From: Jason Smith <smithjw1970@hotmail.com>
Sent: Wednesday, April 02, 2014 12:27 PM
To: Rose Shriner
Cc: Jeff Watson
Subject: Re: CU13-00008 Helena Substation

Well shoot it is right next to my houses on Helena, I have a few concerns related to my investment property's future value and more importantly for my current and future tenants safety due to irradiation and prolonged exposure to the substation given the proximity to my homes. This is an area where I have not done current research, but would appreciate the project proponent being proactive.

**HELENA AVENUE SUBSTATION**  
 SITE PLAN OVERVIEW  
 CITY OF ELLENSBURG  
 501 NORTH ANDERSON STREET  
 ELLENSBURG, WA 98926

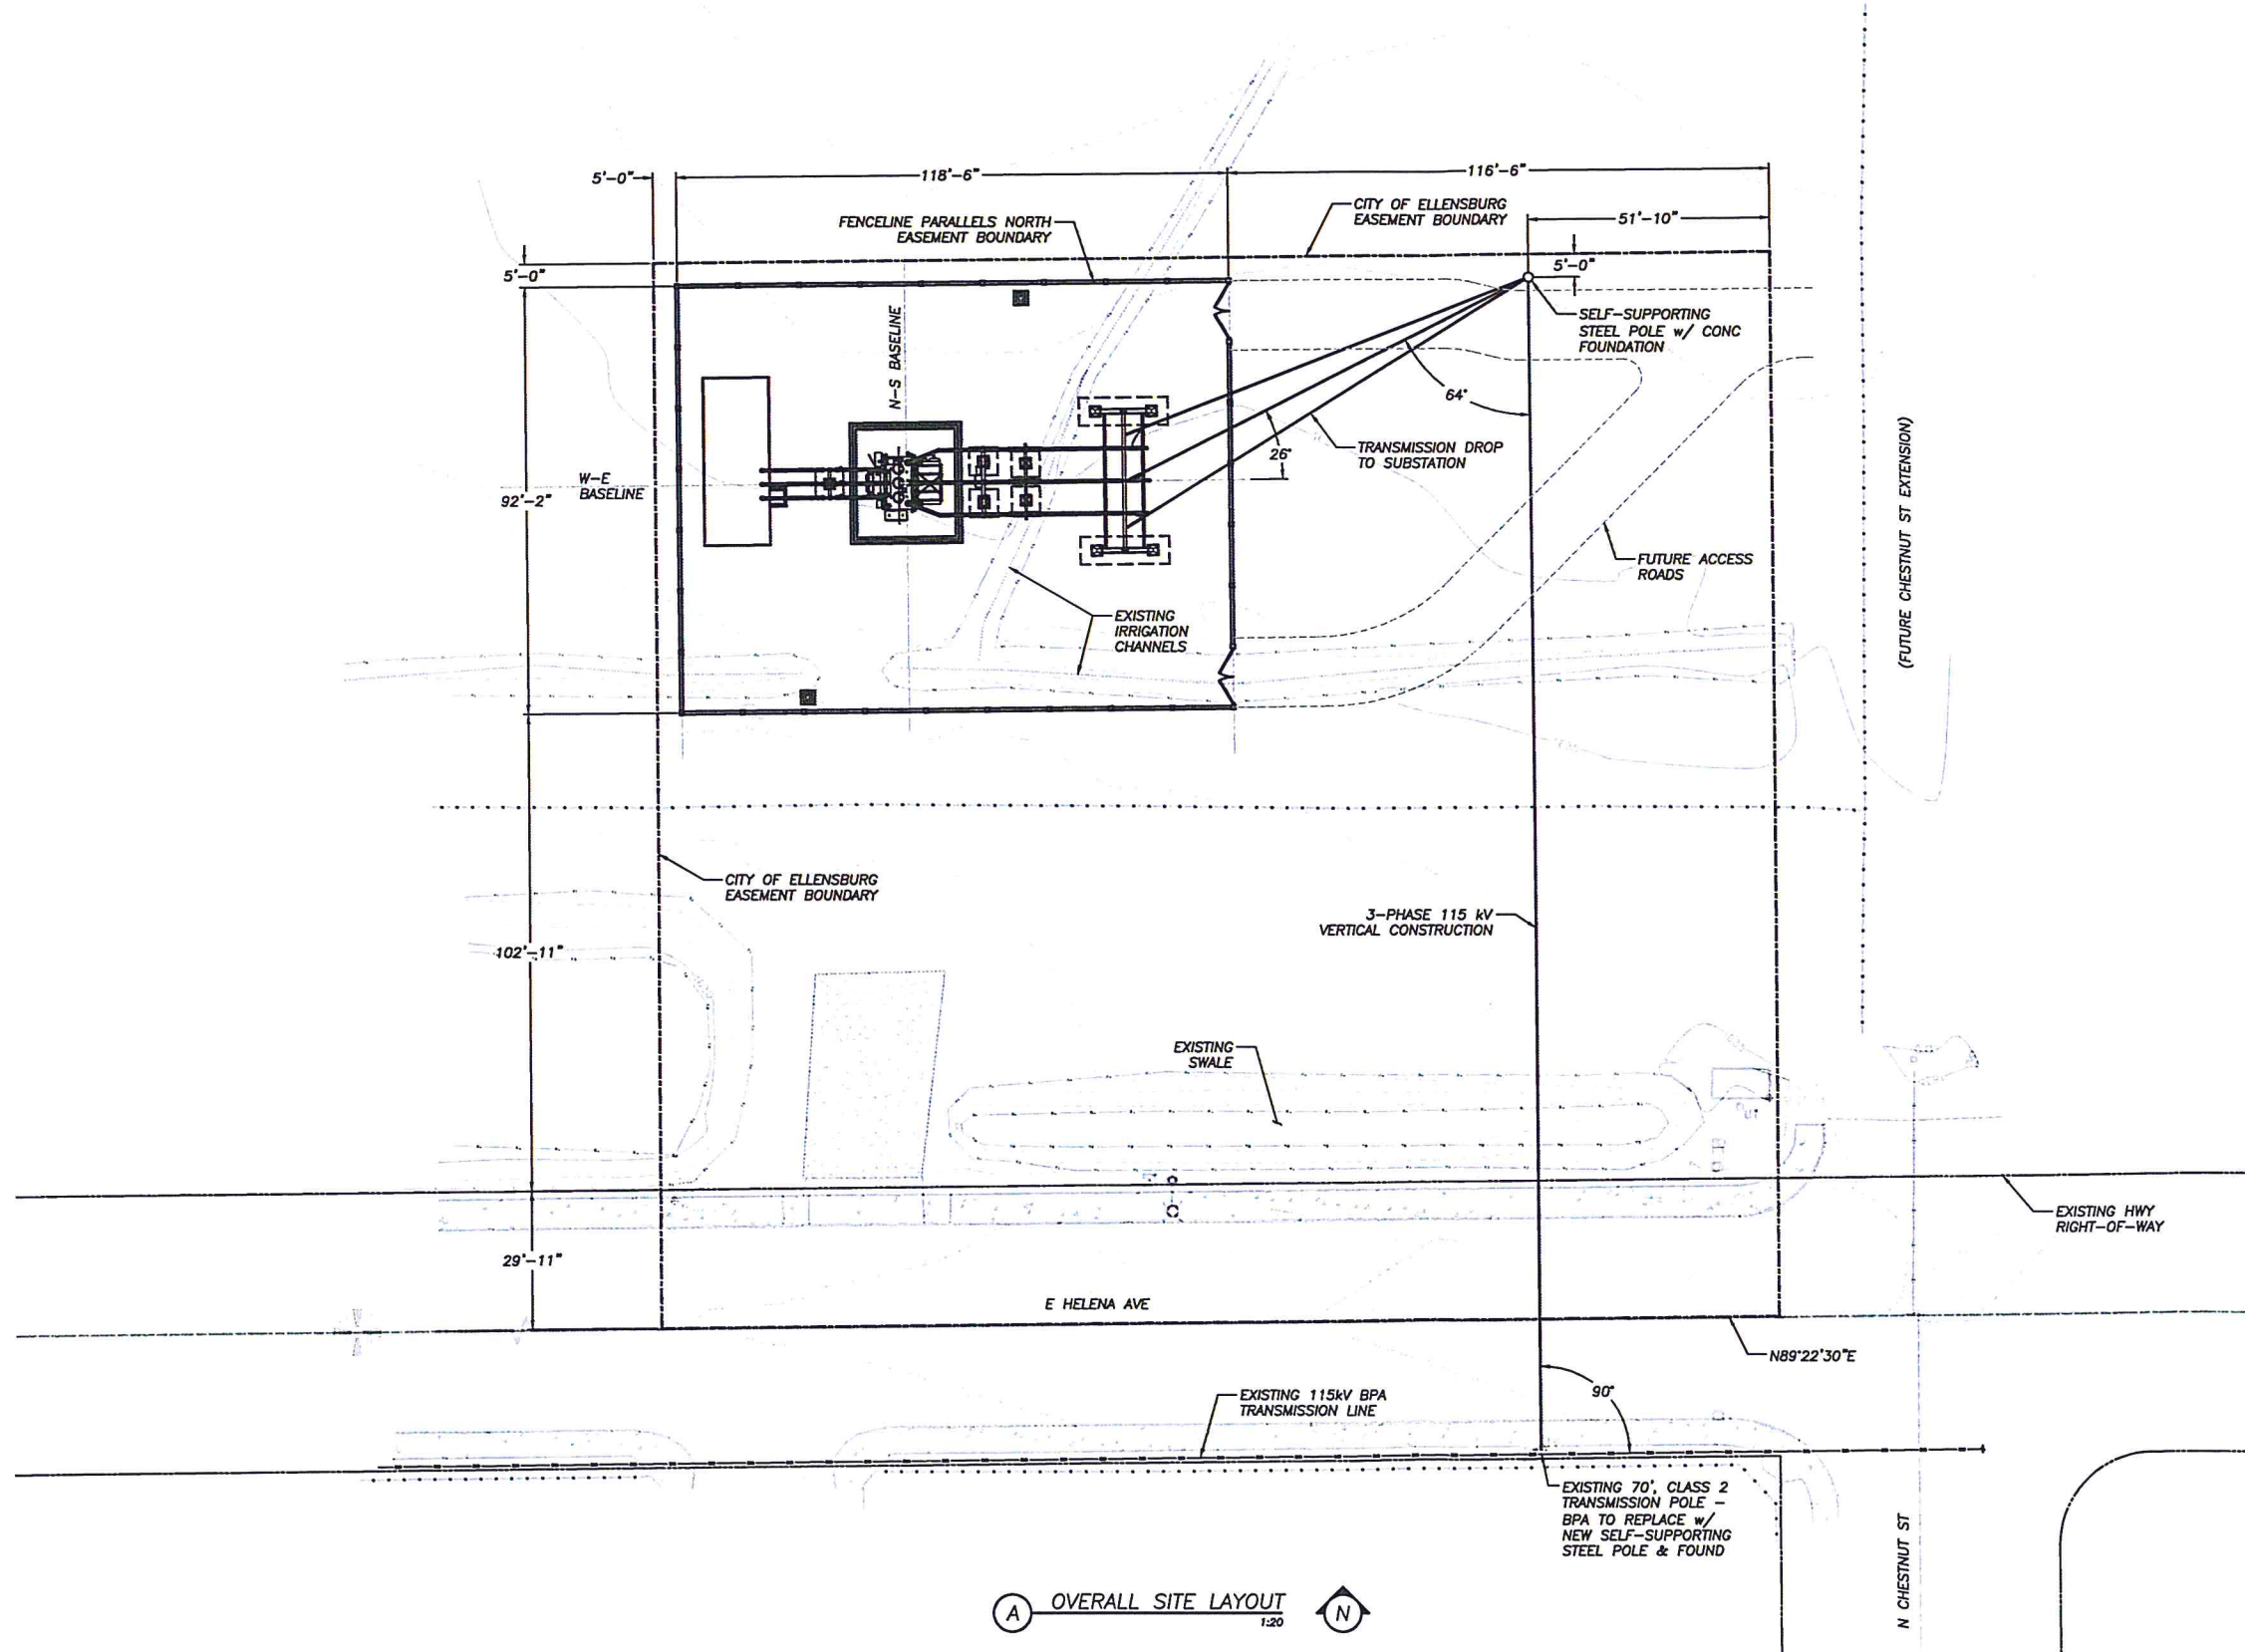
Was any attention paid to siting the facility an optimum distance from my property line. The property line proximity is my primary concern as the zoning is RM and I plan to add 1-3 units to my combined property in the near future.

Lastly is the issue of aesthetics, I bought the property with the understanding that the surrounding property's underlying zone was RM and RS. Placement of the substation right next to the property will likely be an impact to my property with no value added.
